CASA Ref: F23/33352-59

DPHI ref: SSD-77458970 Email Wed 11/12/2024

MIXED-USE RESIDENTIAL AND COMMERCIAL DEVELOPMENT (SSD-77458970) (LIVERPOOL CITY) 135 BADGERYS CREEK ROAD CASA COMMENTS ON SEARS

Figure 2: Built structure penetrating the WSA OLS (126m AHD at the site)

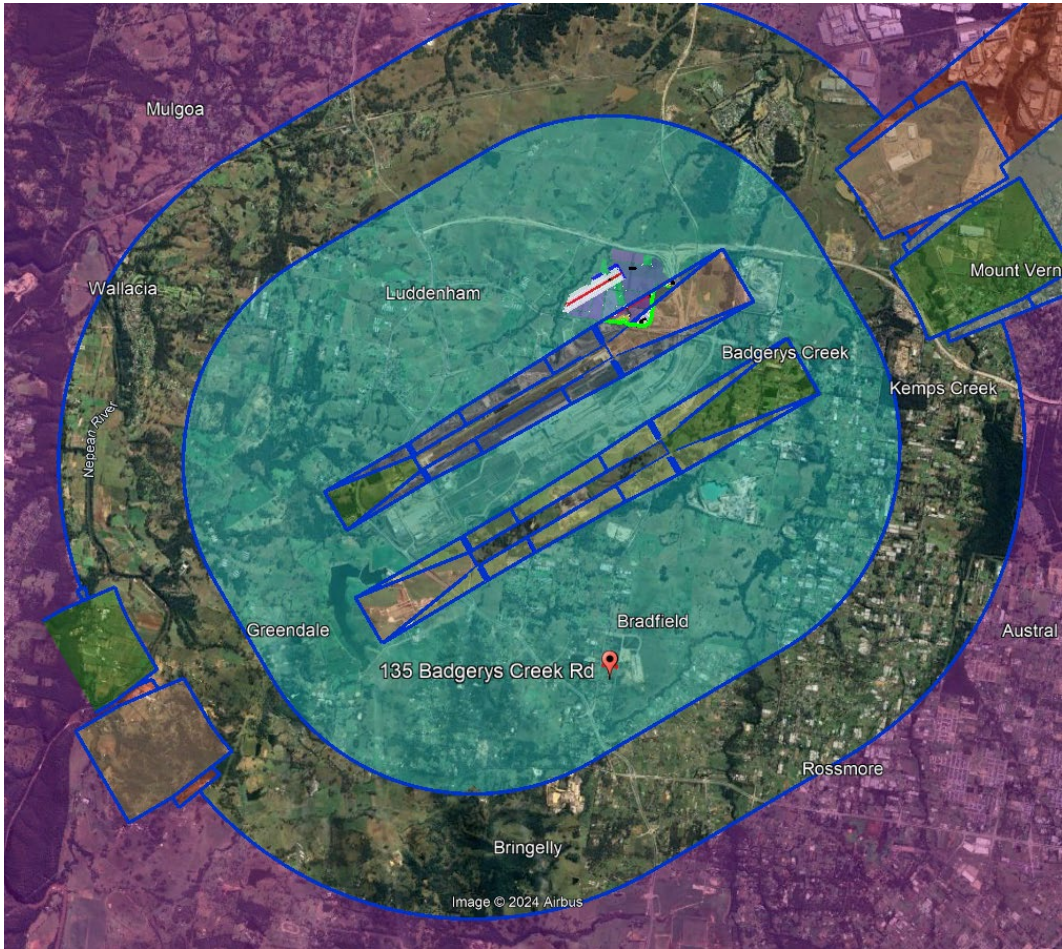
Regarding Aviation Safety, the Interim Aviation Safeguarding Assessment advises the elevation of a crane will be up to 228.8m. The Scoping Report advises that PANS-OPS is expected to be approximately 165m AHD, the OLS is 126m AHD and the max building height is 163.7m AHD. An OLS infringement of approximately 38m.

PANS-OPS (all aspects as far as practical considering that the PANS/OPS or instrument procedures have not been formalised ... development progress, latest approximation, procedures affected, justification and mitigation of crane height up to 228.8m against a PANS-OPS of 165m, Minimum Sector Altitudes, possible changes to procedures in future);

Theory behind the Inner Horizontal Surface and consequences if any of significant infringements (risks of Inner Horizontal Surface infringement);
